Our Ref: 689/013
Your Ref: 18/01333/F
Date: 11th October 2019

VARIATION OF CONDITIONS FOR PLANNING PERMISSION 18/01333/F

We write to submit information for the variation of conditions attached to planning permission 18/01333/F. The application was for the extension to existing Technical Site to provide new employment units comprising flexible B1(c) light industrial, B2 (general industrial), B8 (storage or distribution) uses with ancillary offices, storage, display and sales, together with associated access, parking and landscaping. The application to vary the conditions has been made via the planning portal under reference PP-08147840.

TITLE:
Building A Proposed Elevations

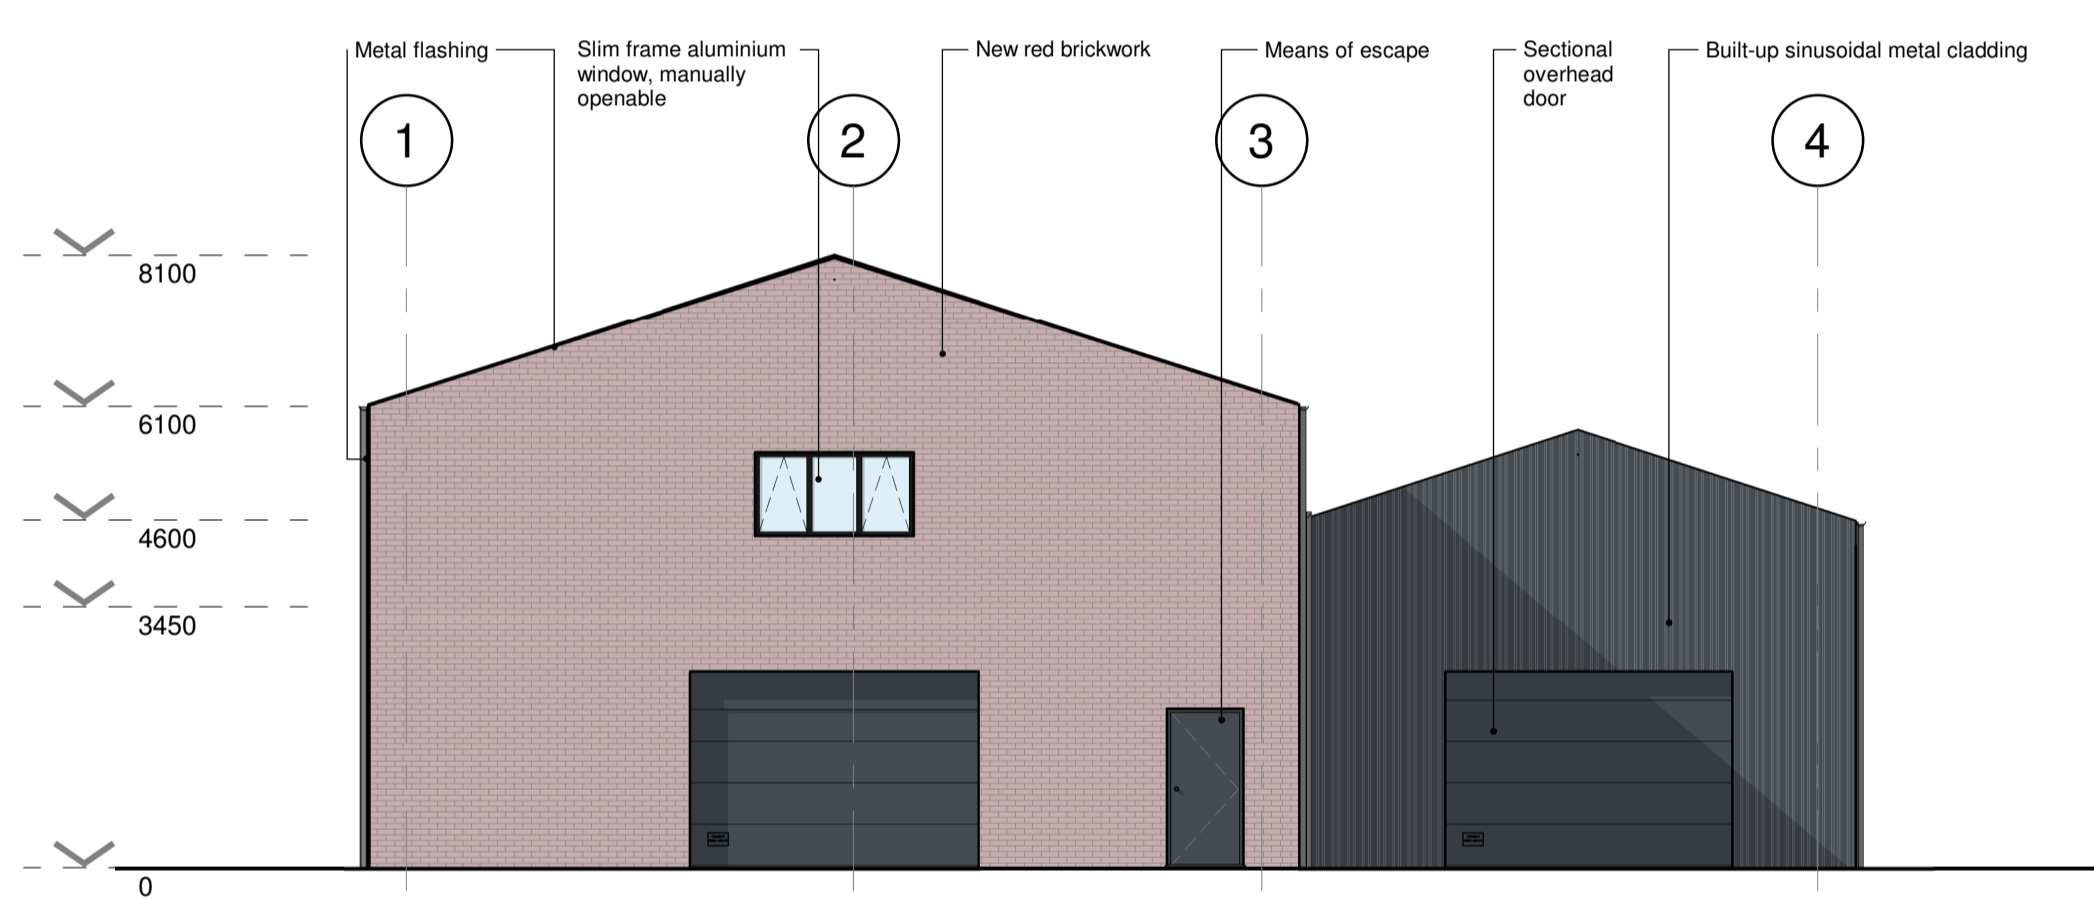
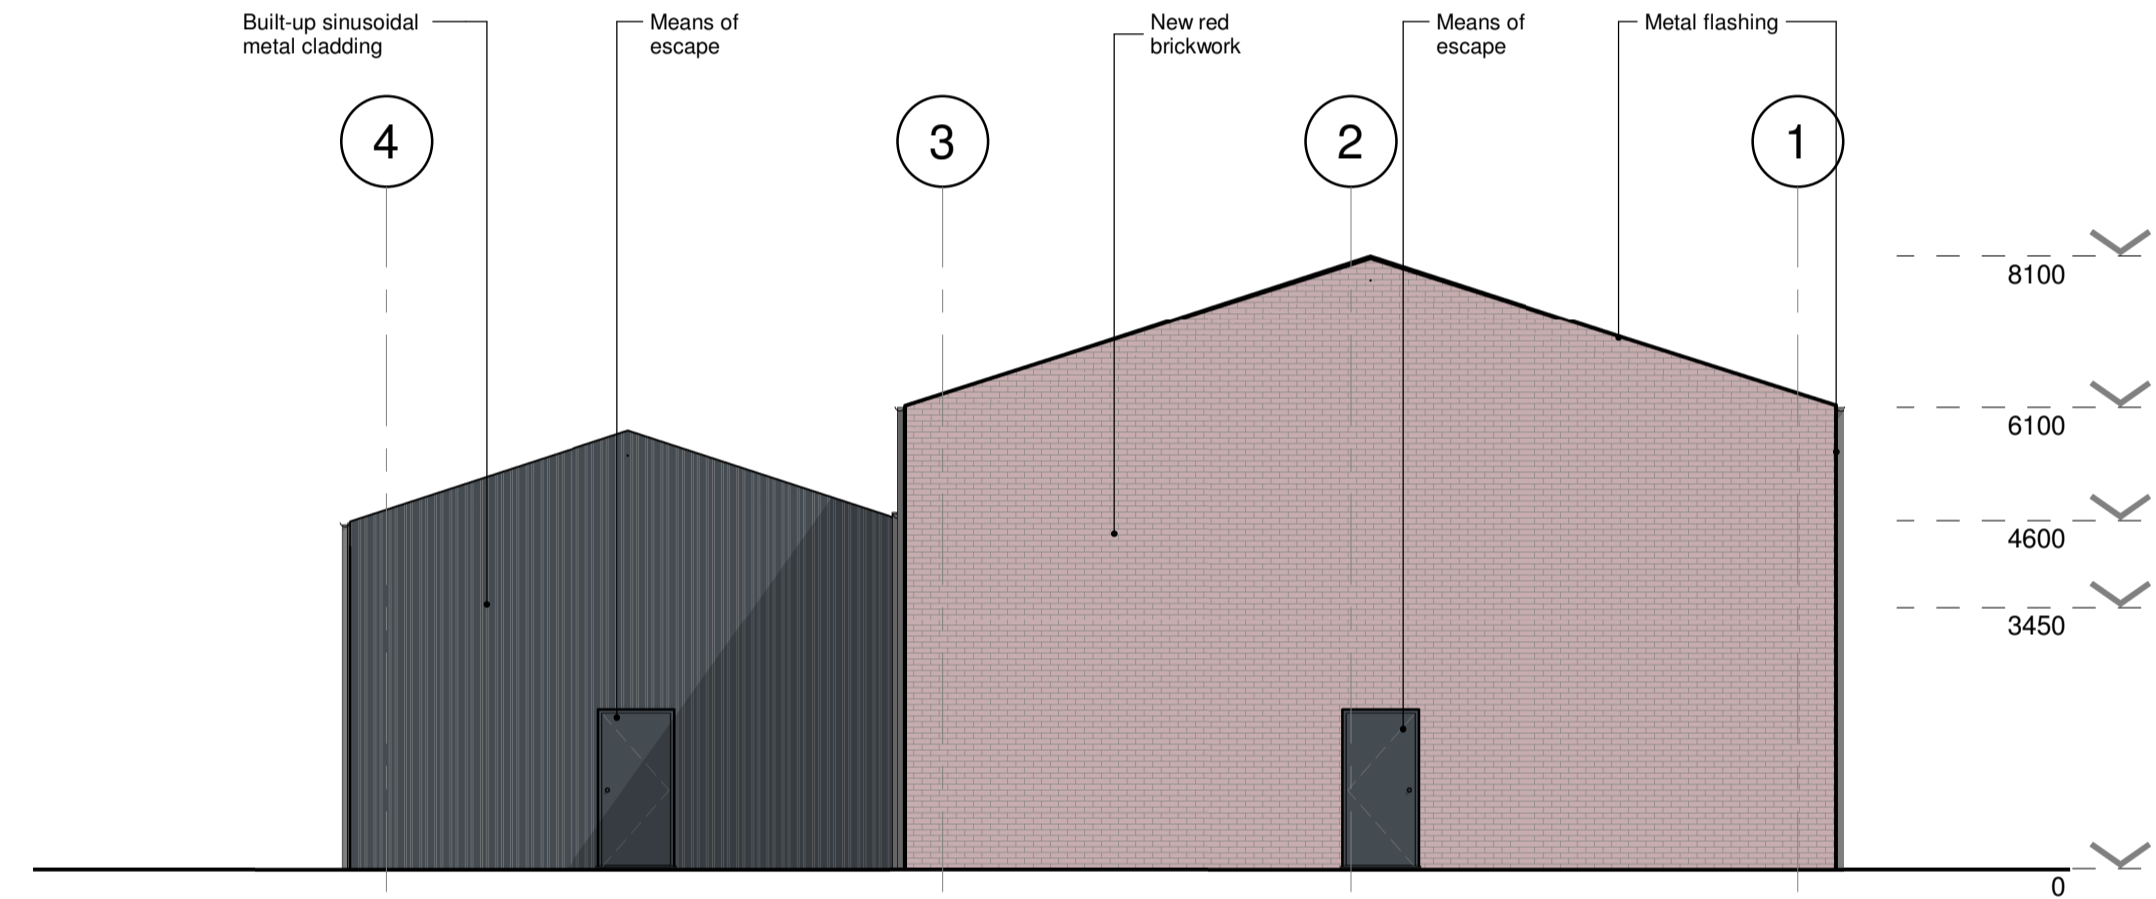
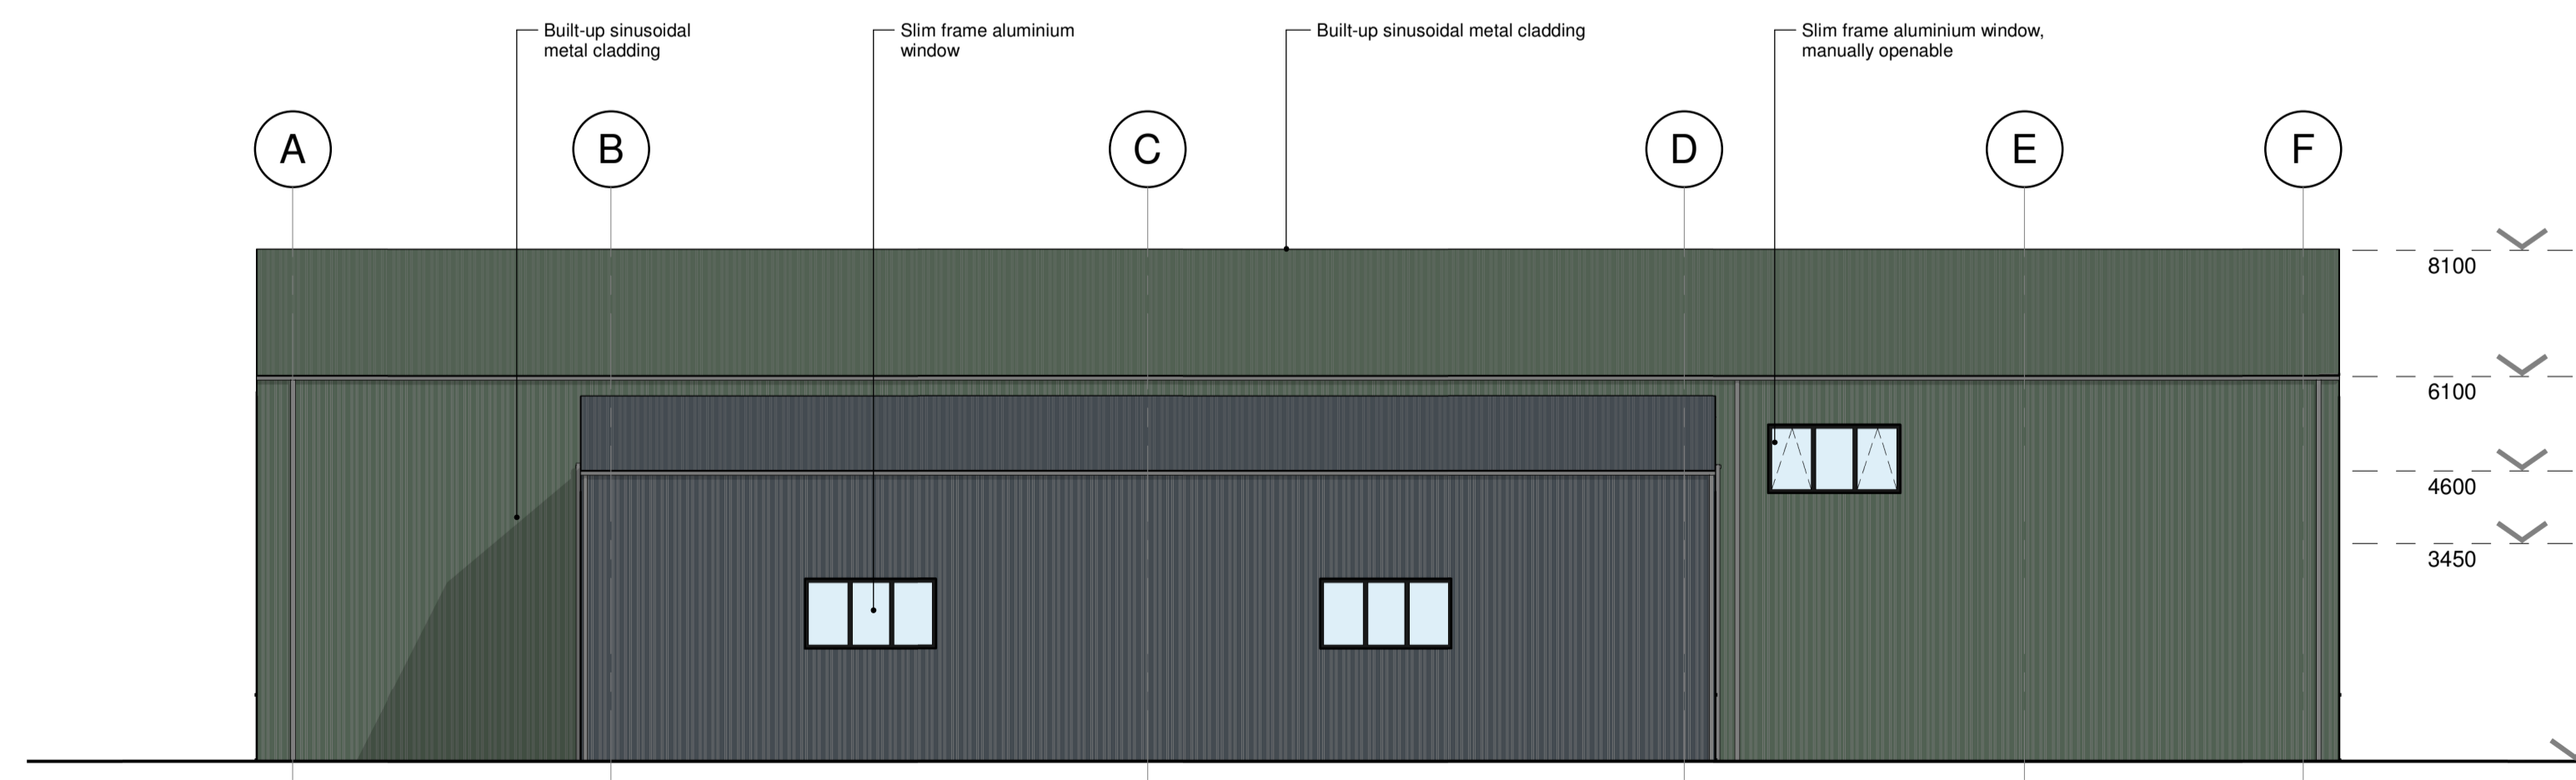
Drawing / Unit		Changes
		Locations of car parking bays
		A new staircase for Unit C added
		Future charging points introduced
		Infiltration basin shape changed
		Surface Treatment amendments around buildings
Unit A	GF	A sectional overhead door replaced with fully openable glass panel
		Two high level windows added
Unit B	GF	A glass panel with access door replaced with fully openable glass panel
		A sectional overhead door replaced with a glass panel with access door
		A sectional overhead door removed
		A glass panel with access door replaced with a sectional overhead door with wicket door
		An escape door added
		An escape door relocated
		Staircase relocated
	FF	A window relocated
		A window size increased, and window relocated
	Roof	Four rooflight added
		One rooflight relocated
		One rooflight size decreased
	Unit C	GF
External staircase and balustrade added		
FF		Two windows added
		One access door to terrace added
